Your ref:
Our ref: 23/01618/F
Please ask for: Mrs Lesley Raby
Direct dial: 01553 616818
E-mail: borough.planning@west-norfolk.gov.uk

Details: **Erection of single-storey front, side, and rear extension(s) and detached garage.
at Cleveland House 10 Gayton Road Ashwicken Norfolk PE32 1LS**

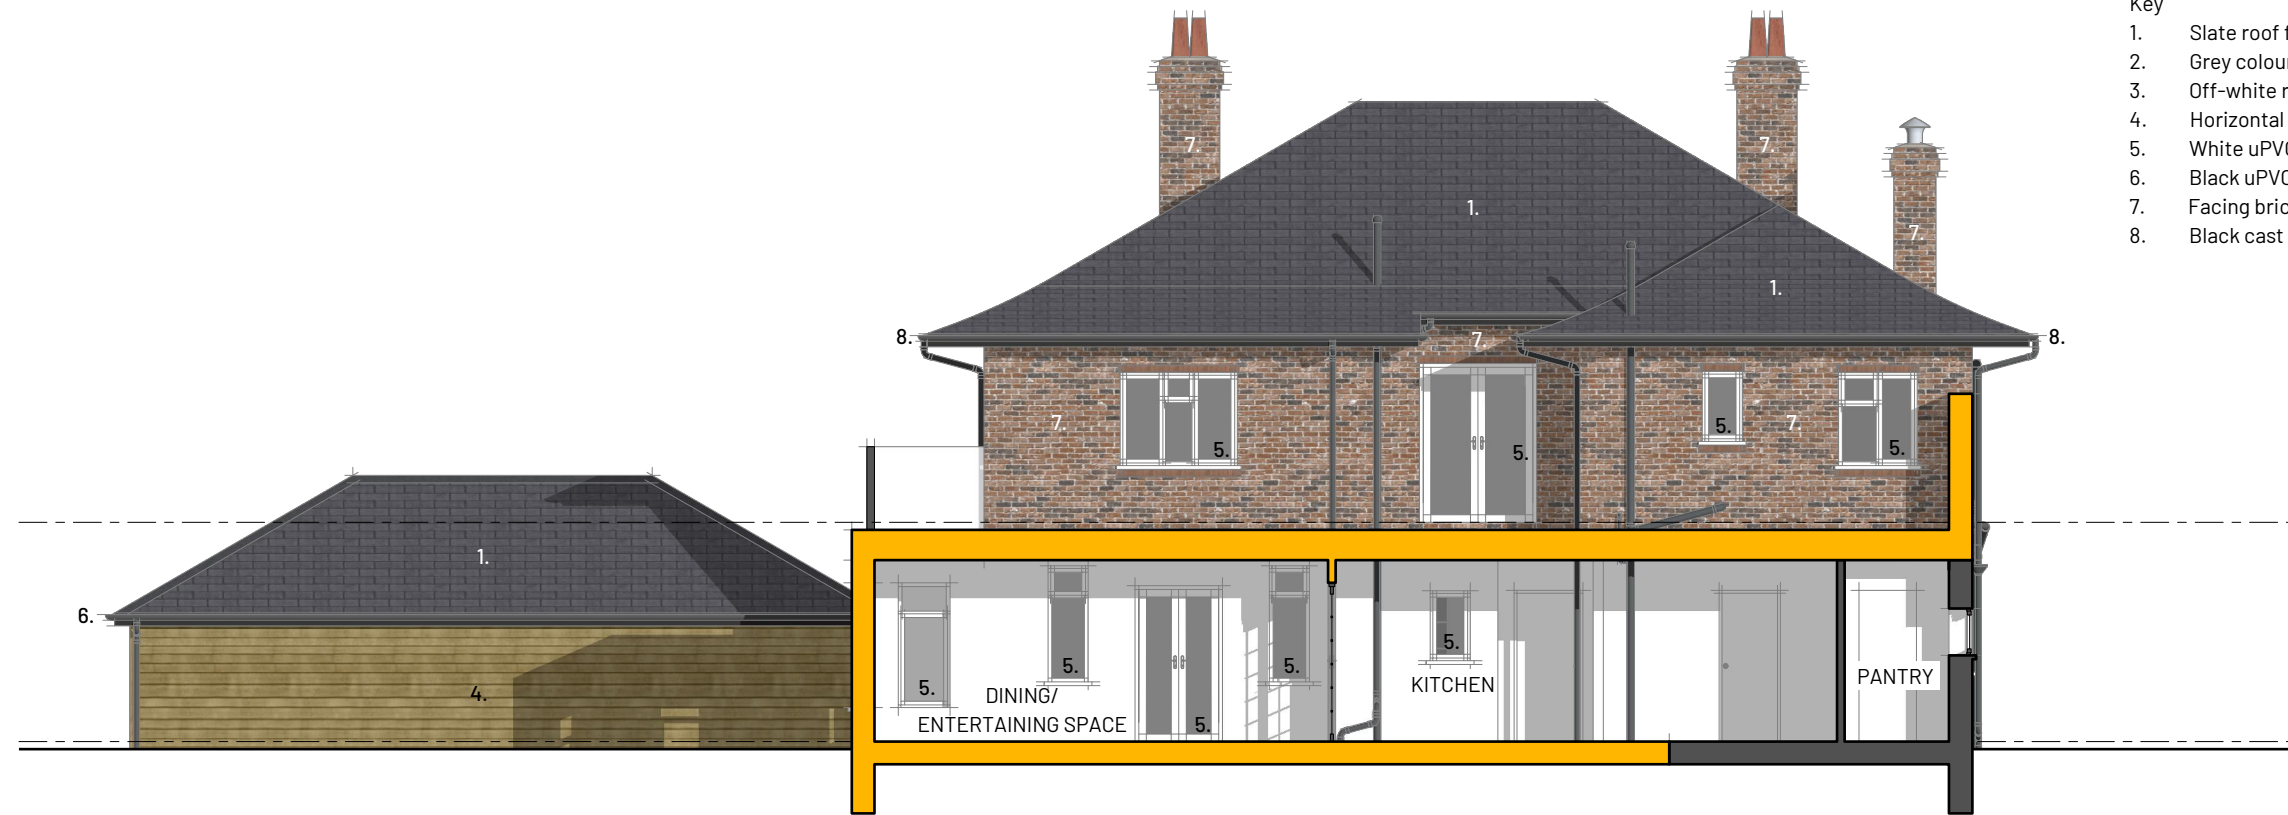
1. Provide the side elevations of the new garage.
2. Confirm that the site levels will remain as existing.
